## Appeal Decision

**Appeal Ref: APP/R5510/D/22/3294276**

**9 Angus Drive, Ruislip HA4 0RZ**

PROPOSED FLOOR PLANS

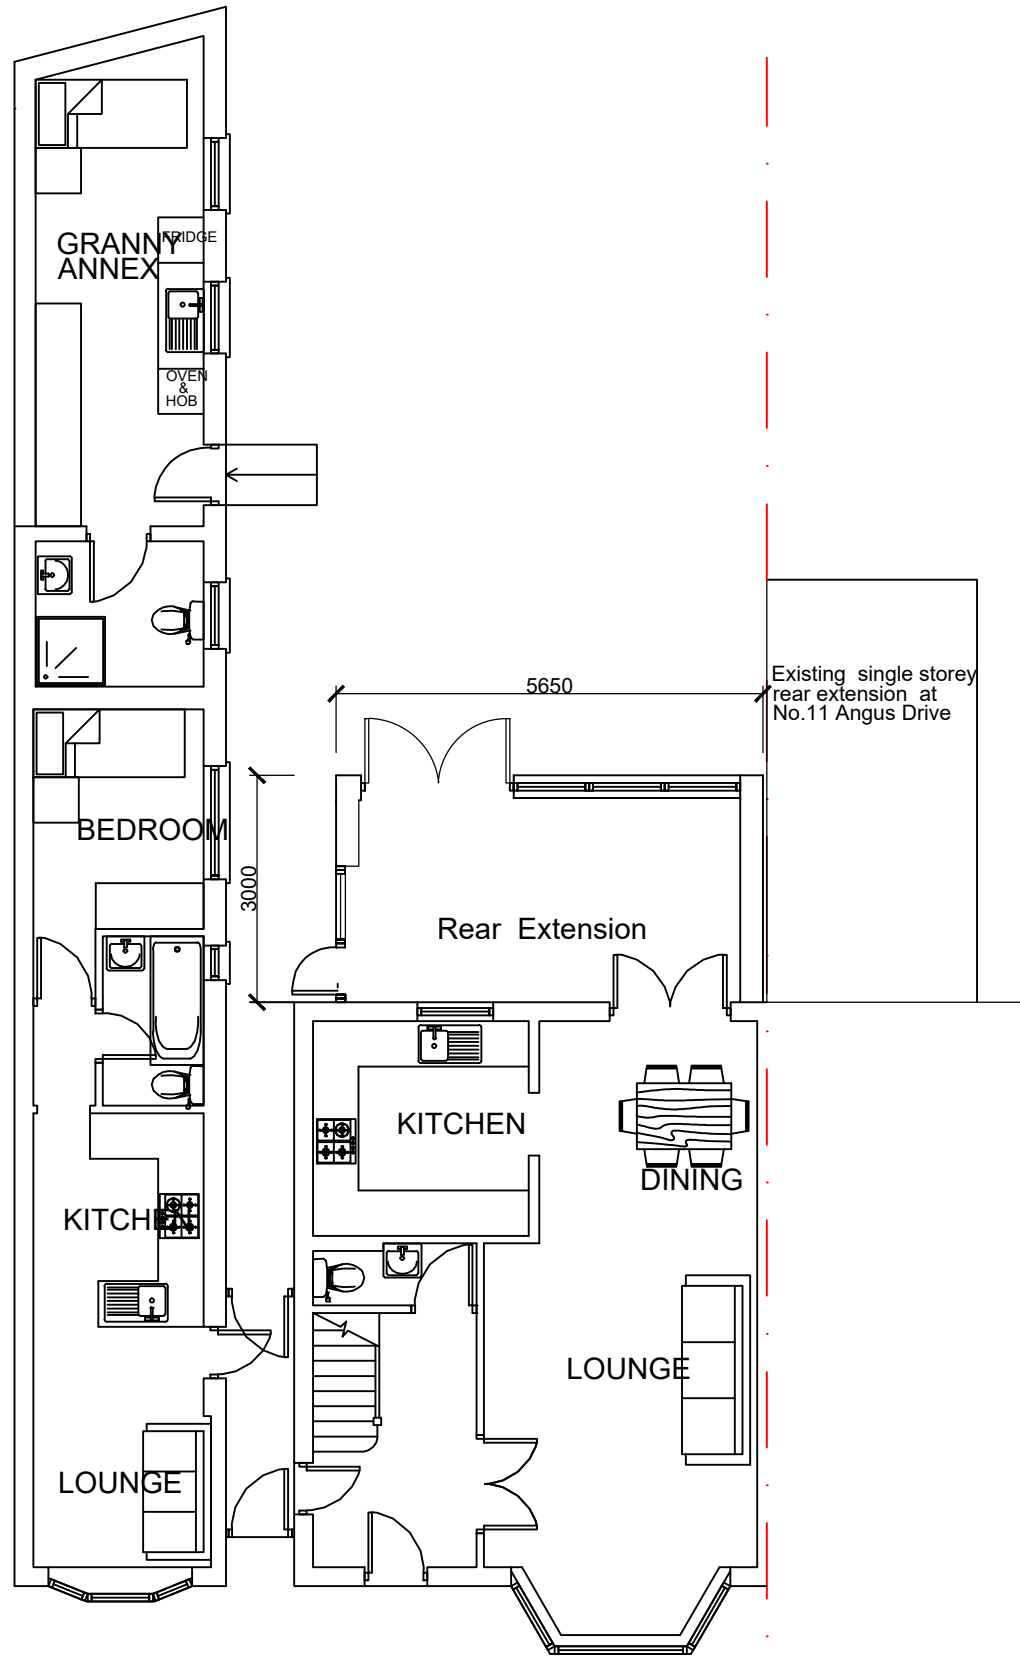
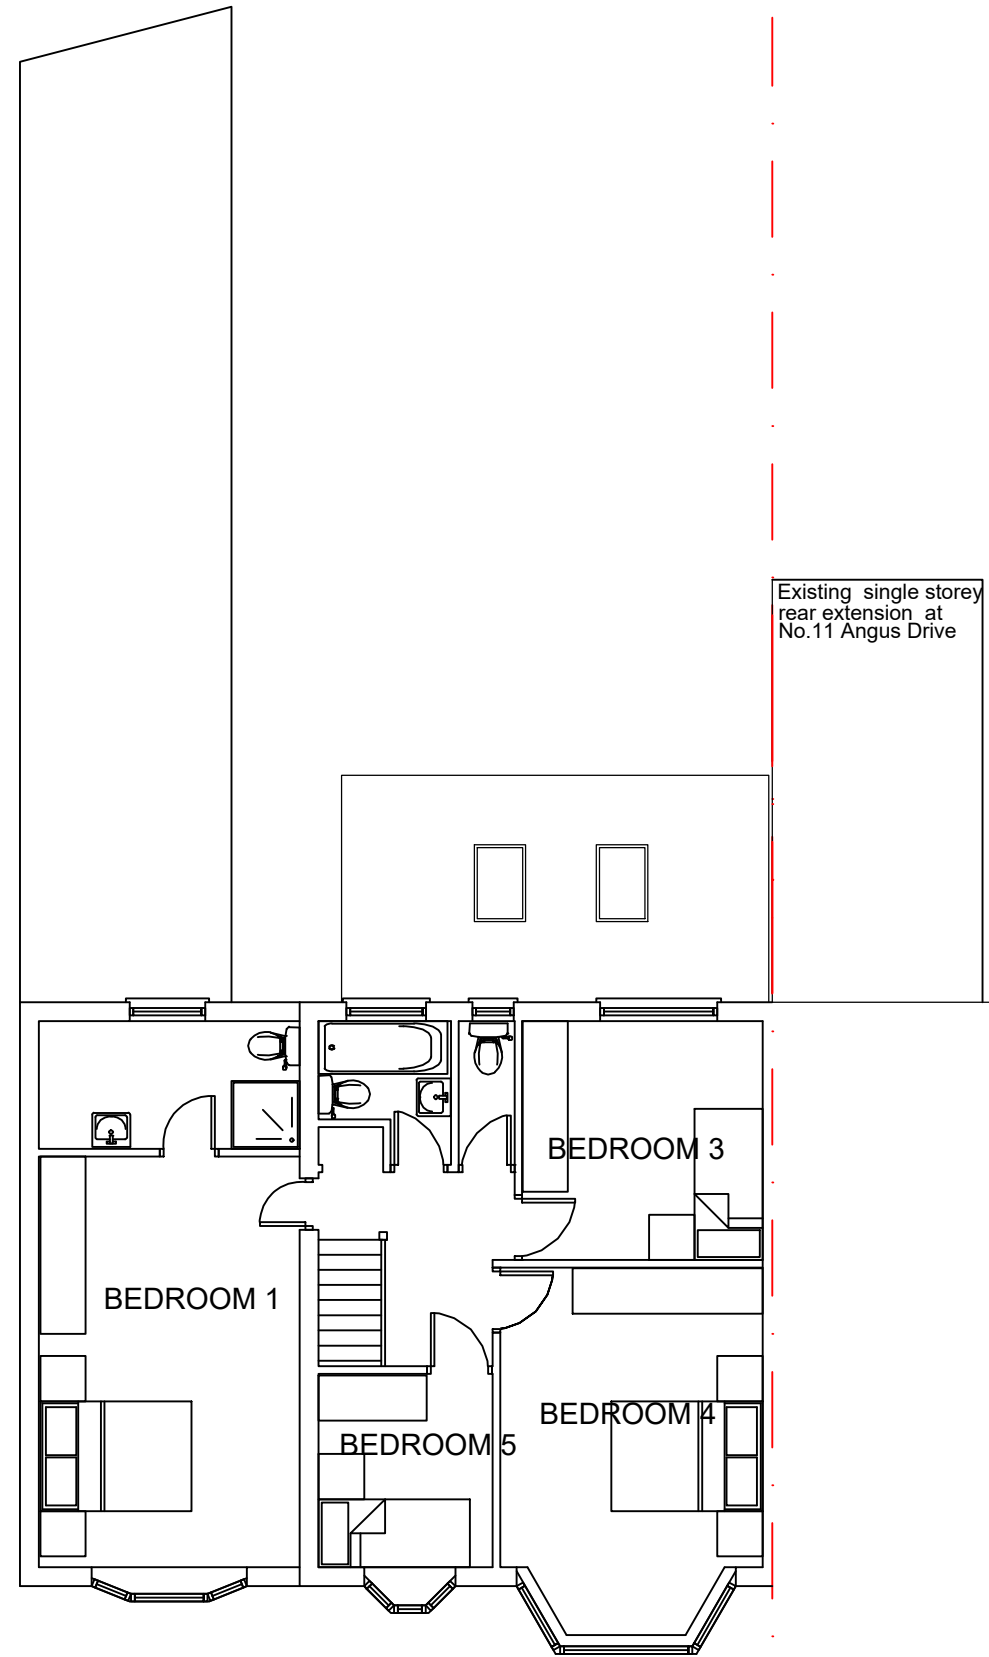
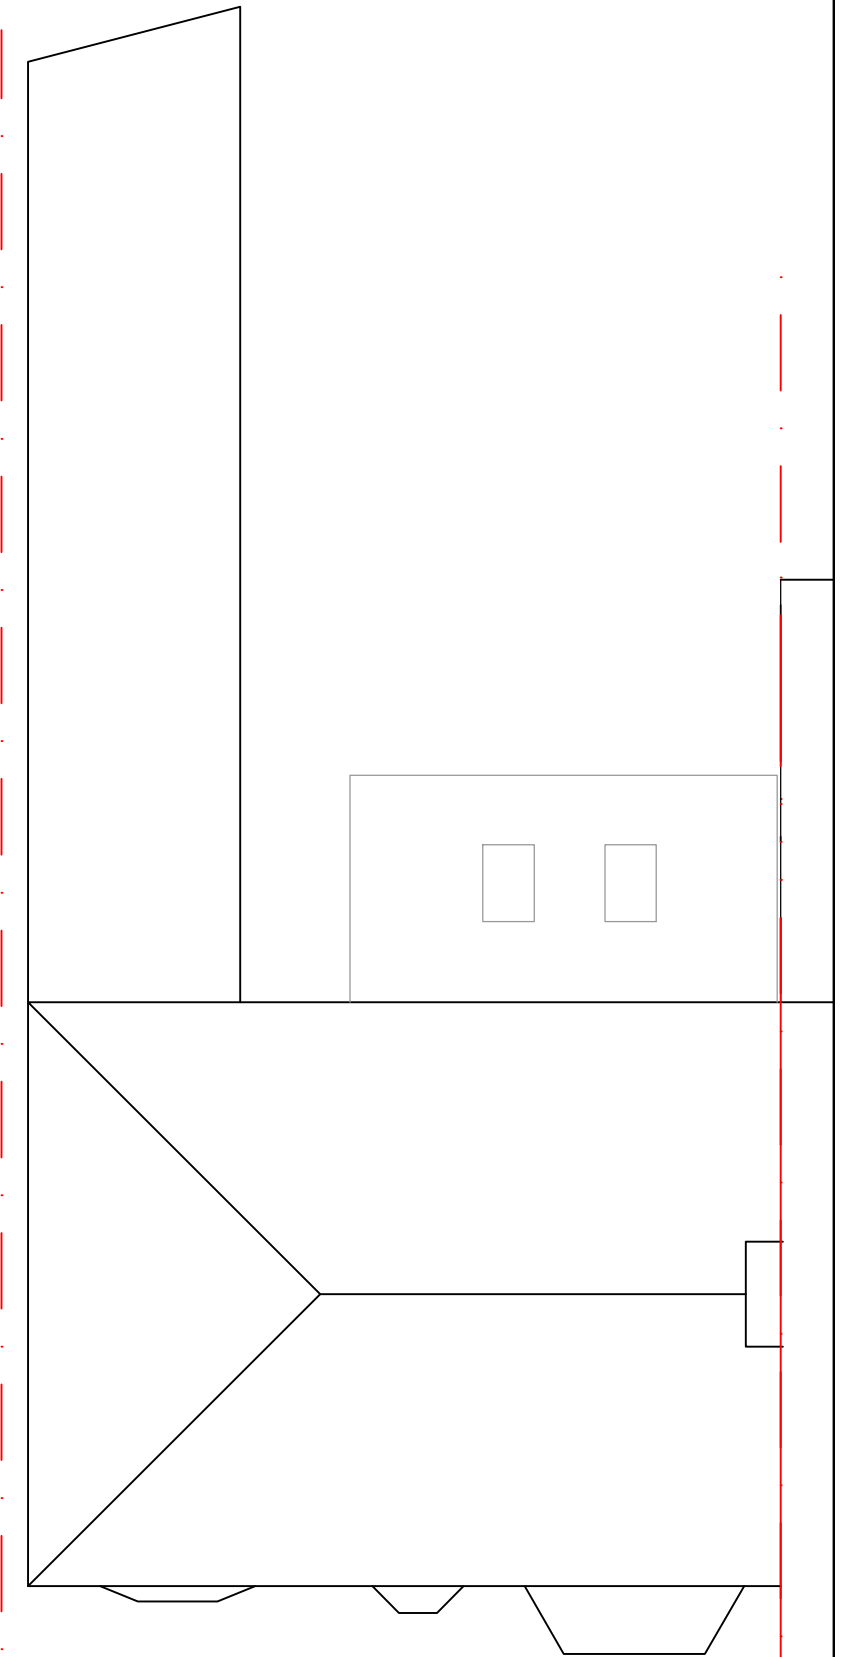
5. The appeal scheme proposes the replacement of the existing conservatory with a single storey rear extension. The appellant details that the proposed extension is approximately 0.1m deeper and 0.8m wider than the existing structure. The increased width would bring it closer to the existing rear extensions, in particular a bedroom window.

6. Nonetheless, on the basis that the proposed extension will only be marginally closer to this room, that is used as a bedroom and does not form a separate dwelling, and that the appeal scheme would be of specific benefit to the occupier of the bedroom, I am satisfied that the living conditions of the occupiers of the properties on the site will not be materially harmed by the appeal scheme.
